Your Ref: ACP-324164-26

Our Ref: SID-TN-2026-012

Proposed Strategic Infrastructure Development (SID): Renewable energy development Carrow Wind Farm which will include 14 no. wind turbines and associated infrastructure in the townlands of Carrow and adjacent townlands, Co. Tipperary, including underground cabling to connect to the proposed 110kV onsite substation, electrical cabling for 110kV grid connection to the existing Kilonan 110kV Substation, in the townlands of Kilonan and adjacent townlands, Co. Limerick, and all associated infrastructure and works in the townlands of Carrow and adjacent townlands with connection to Substation, in the townlands of Kilonan and adjacent townlands, County Limerick.

Outlined below are heritage-related observations/recommendations of the Department under the stated heading.

Map Legend

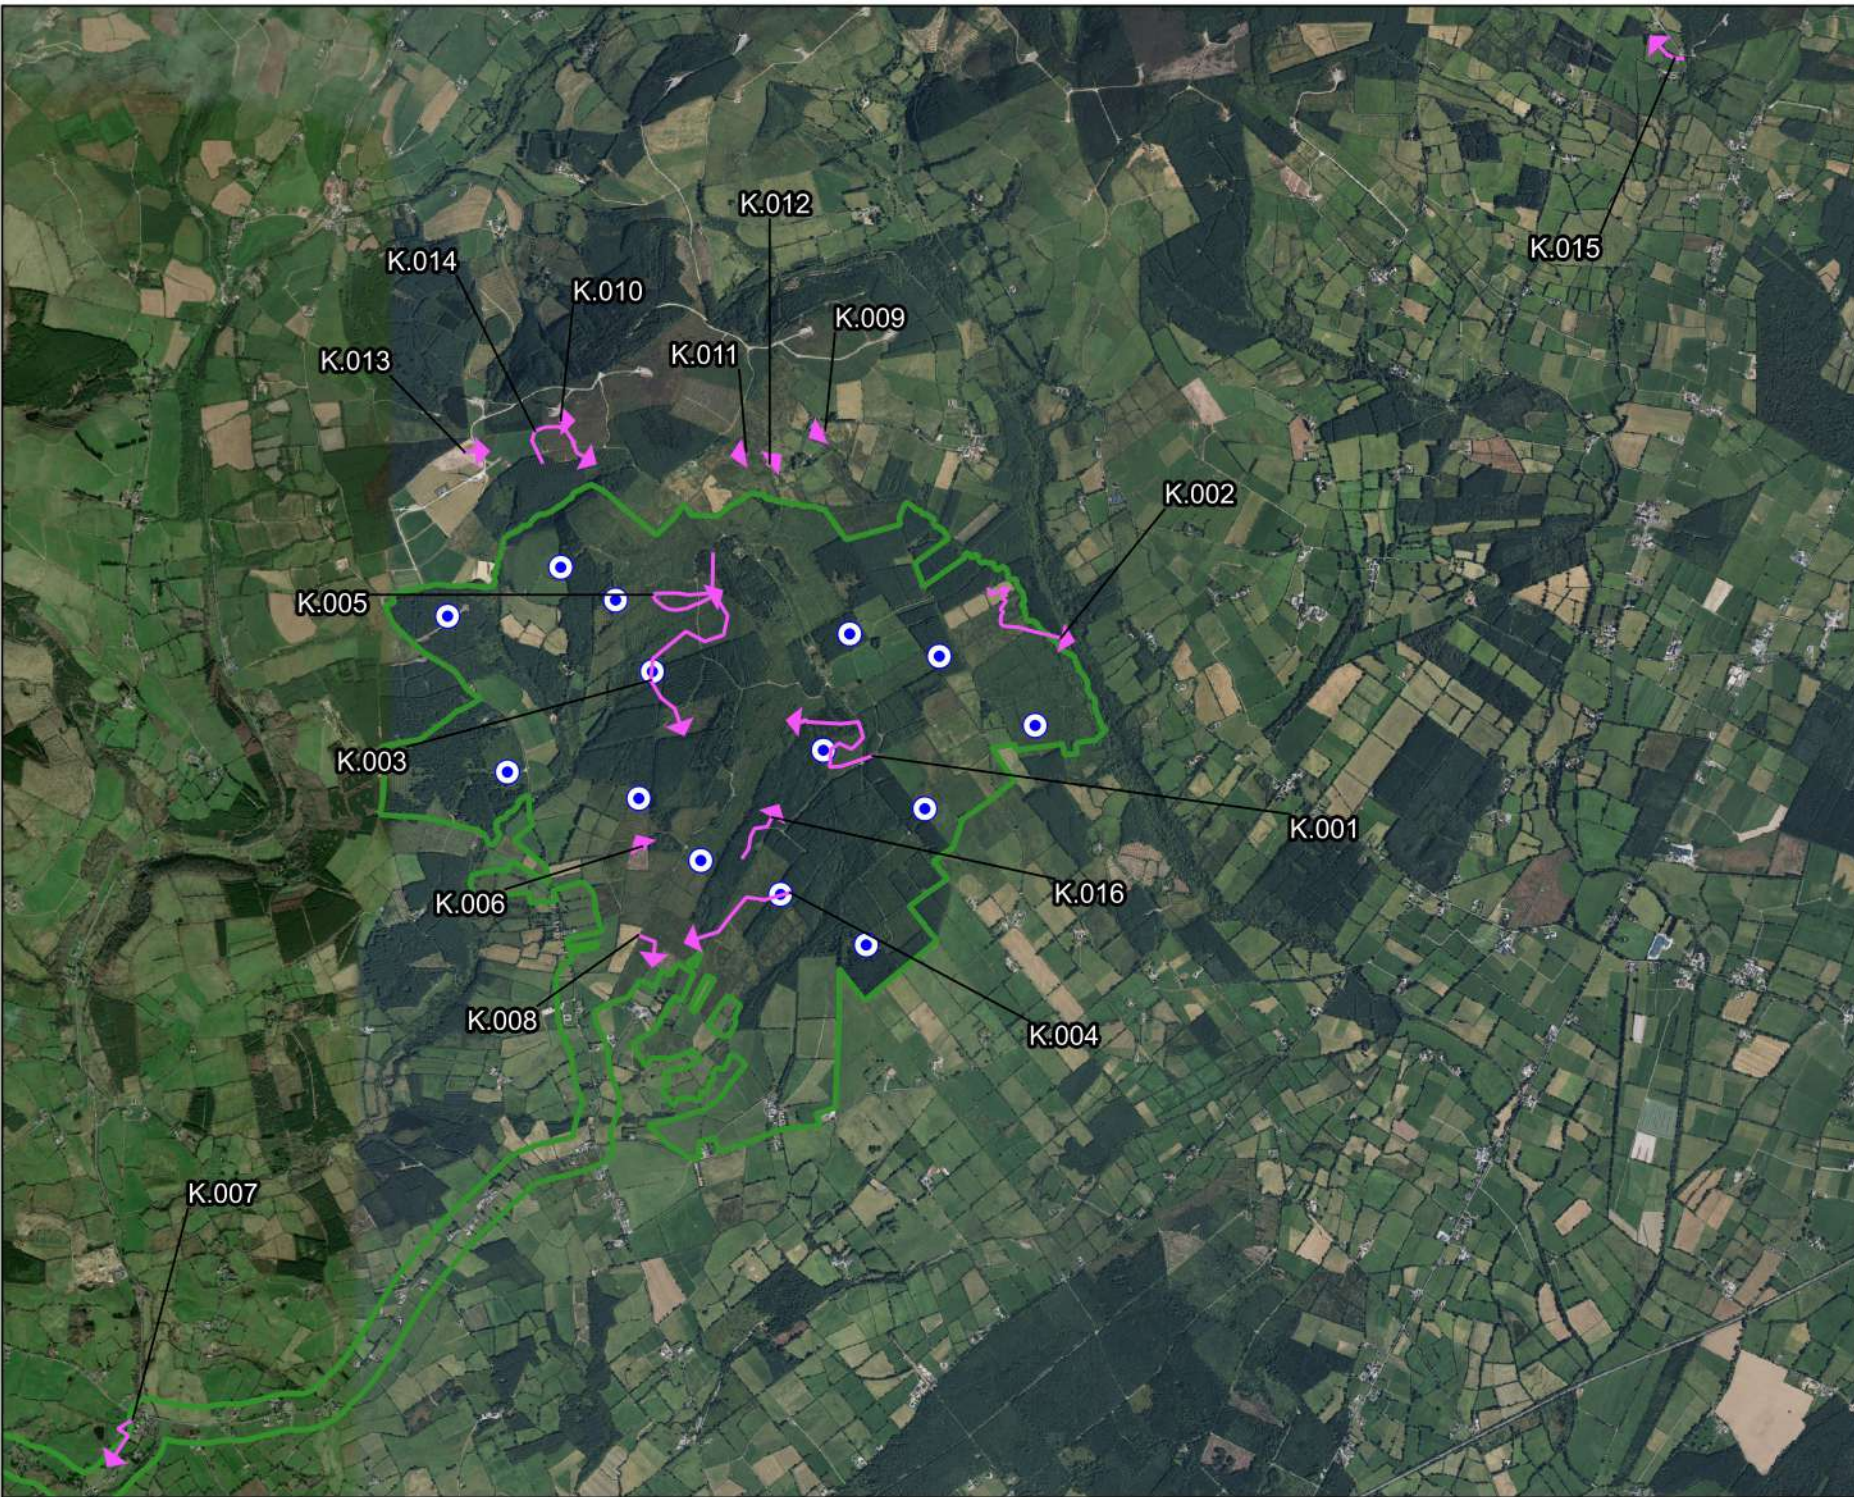
Four breeding Kestrel pairs have been observed on and adjacent to the proposed site, and Kestrels have been observed flying at rotor height. The collision risk has been estimated at 5.4 collisions per year. However, this has been assessed at county level as not significant. The Department considers that this collision risk at site level is highly significant and given that it is related to a breeding population, has implications for breeding success and recruitment, and could potentially lead to the loss of Kestrel as a breeding species from the locality.

The proposal to erect four Kestrel boxes along the site margins as an enhancement measure is also of concern, given the observed usage of the site by Kestrels breeding in adjacent areas, and the projected collision risk.
